Job ID: 2012-07-4524-ALTCOMM

has permission to build a 138 square foot (egress) stairwell addition.

PROJECT: **FR. HAYES STAIR RETROFIT PROJECT FOR
ST. BRIGID CATHOLIC SCHOOL
695 STEVENS AVENUE
PORTLAND, MAINE 04103**

From: Jonathan Rioux
To: davidleasure@myfairpoint.net
Date: 9/12/2012 9:25 AM
Subject: 695 Stevens Ave.
CC: Pirone, Chris; Wallace, Benjamin

STAIR SECTION - "A-A"

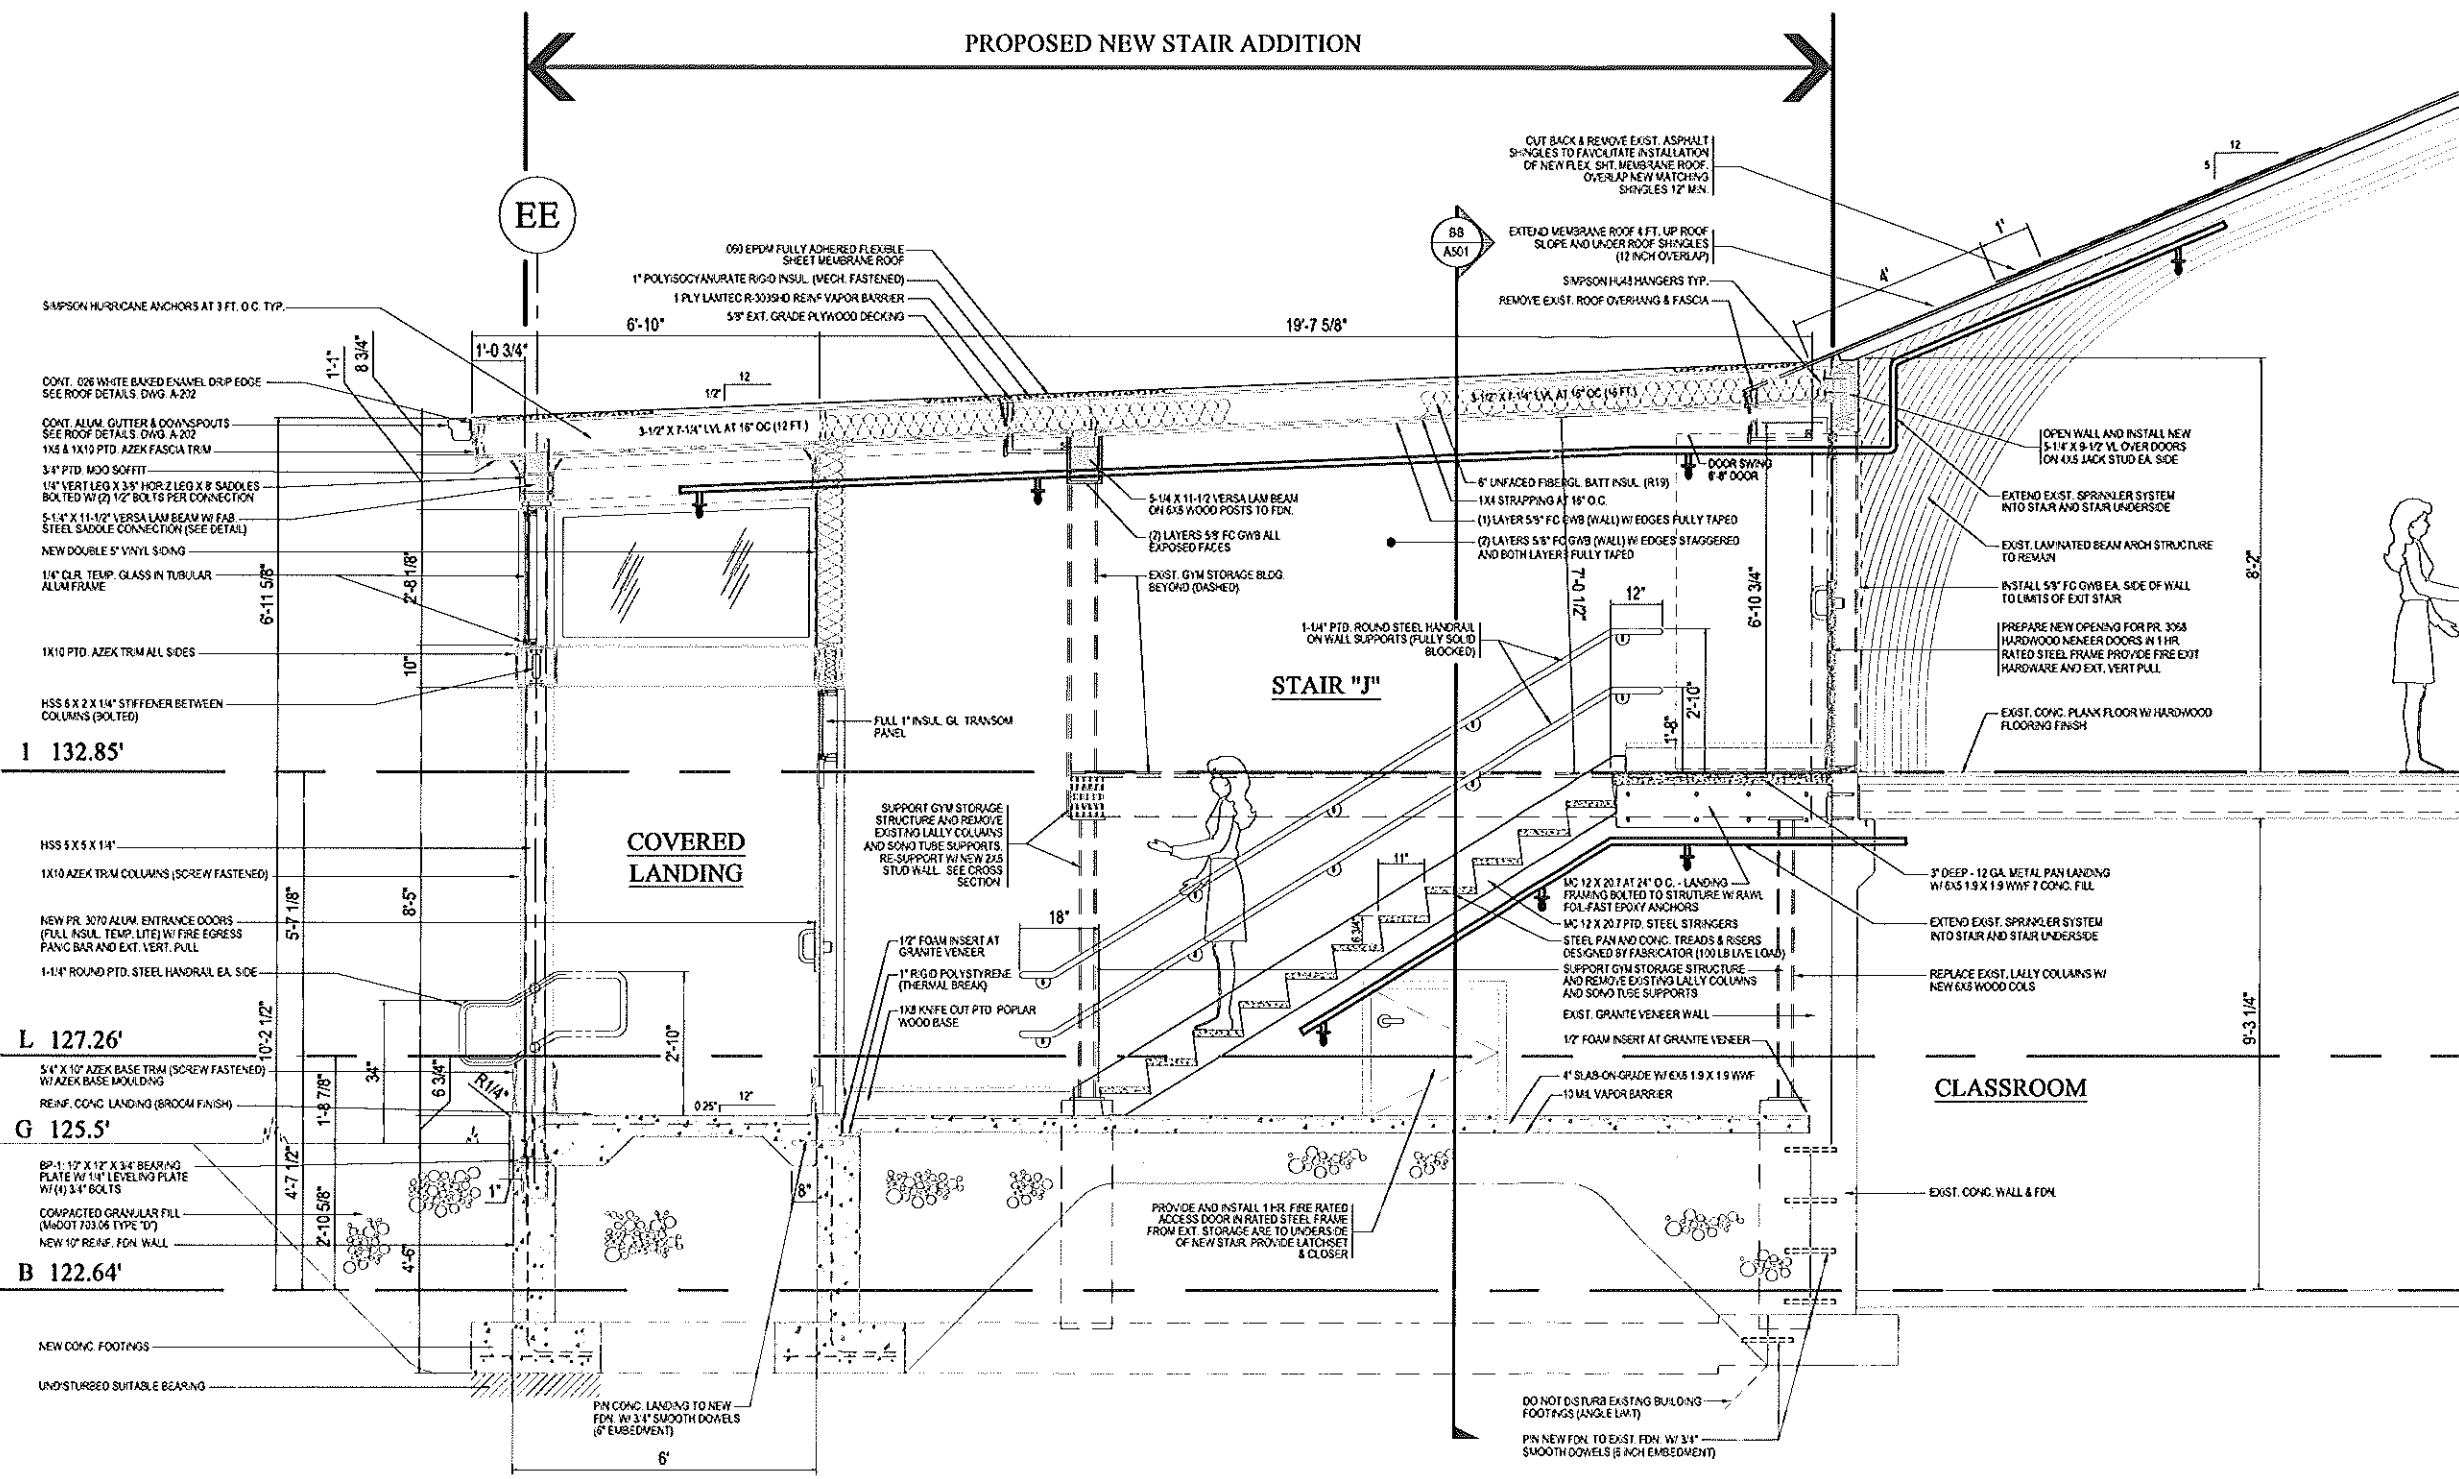
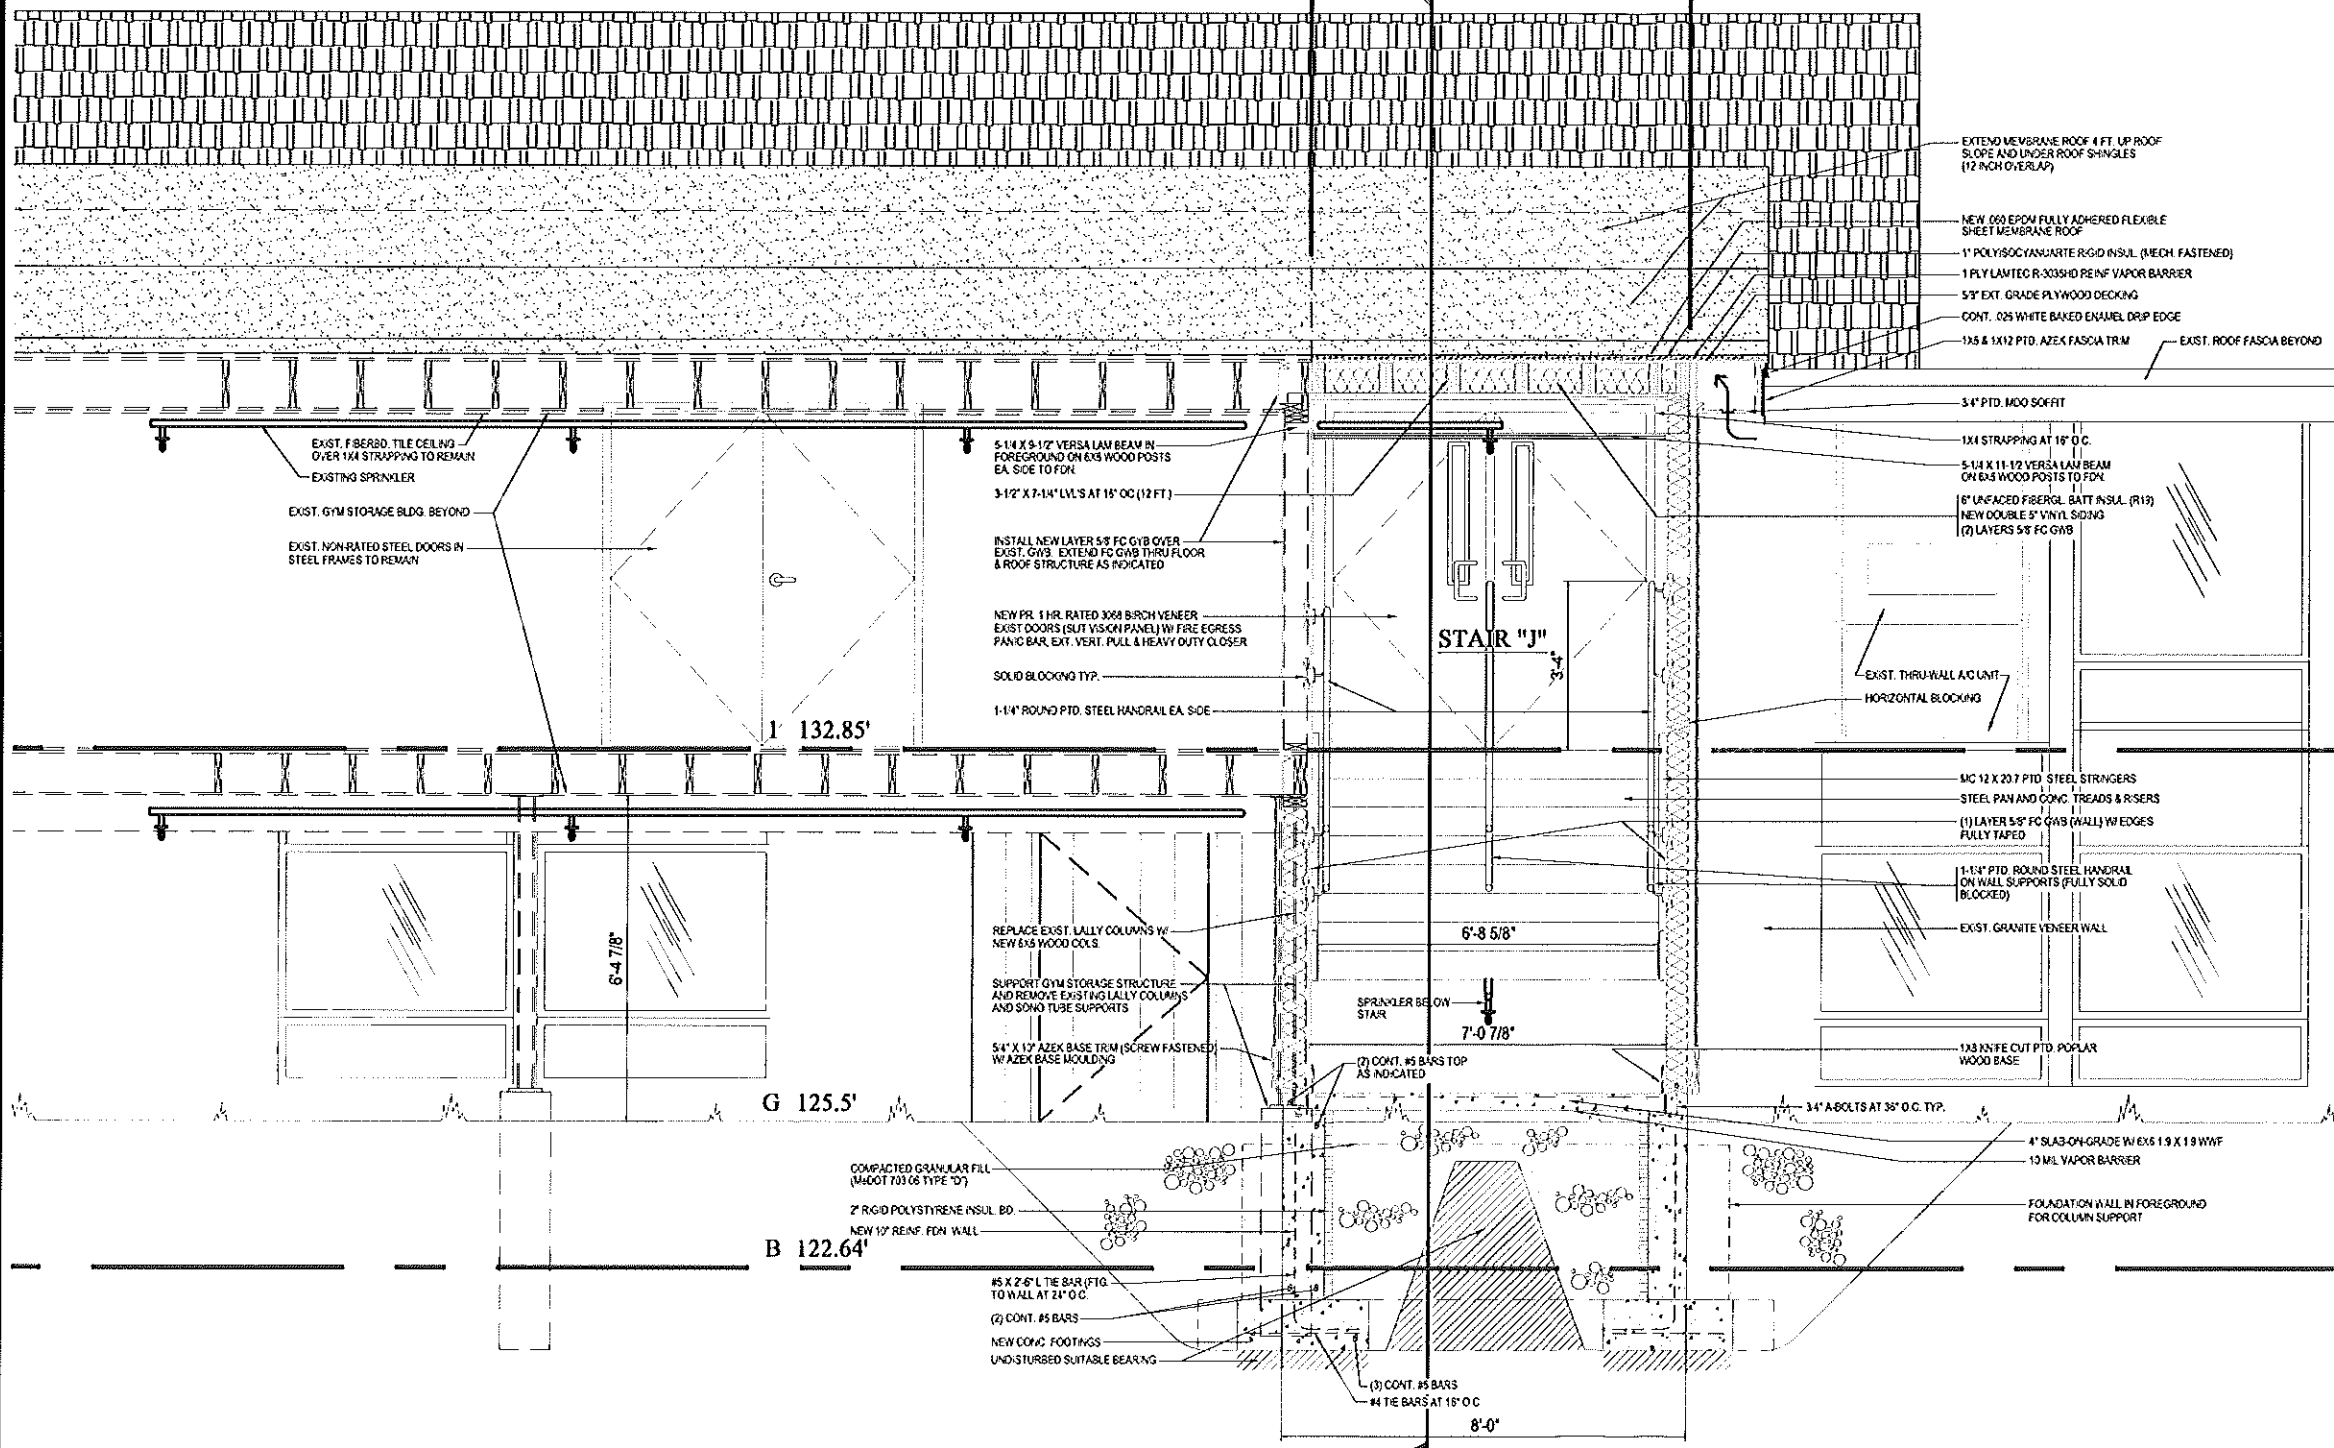
- The submission indicates the stair is to serve as a required means of egress but does not provide a life safety plan indicating occupant load of the space being served and how that's be accommodated. Need a complete seating plan and egress arrangement for the space. I don't believe the gym was approved for assembly use prior to this, and I think that change must be what has triggered the need for another exit and capacity.
- The headroom for the new stair does not comply with 101:43.8.1.1(1) and 101:7.1.5 for headroom at the top landing and door.
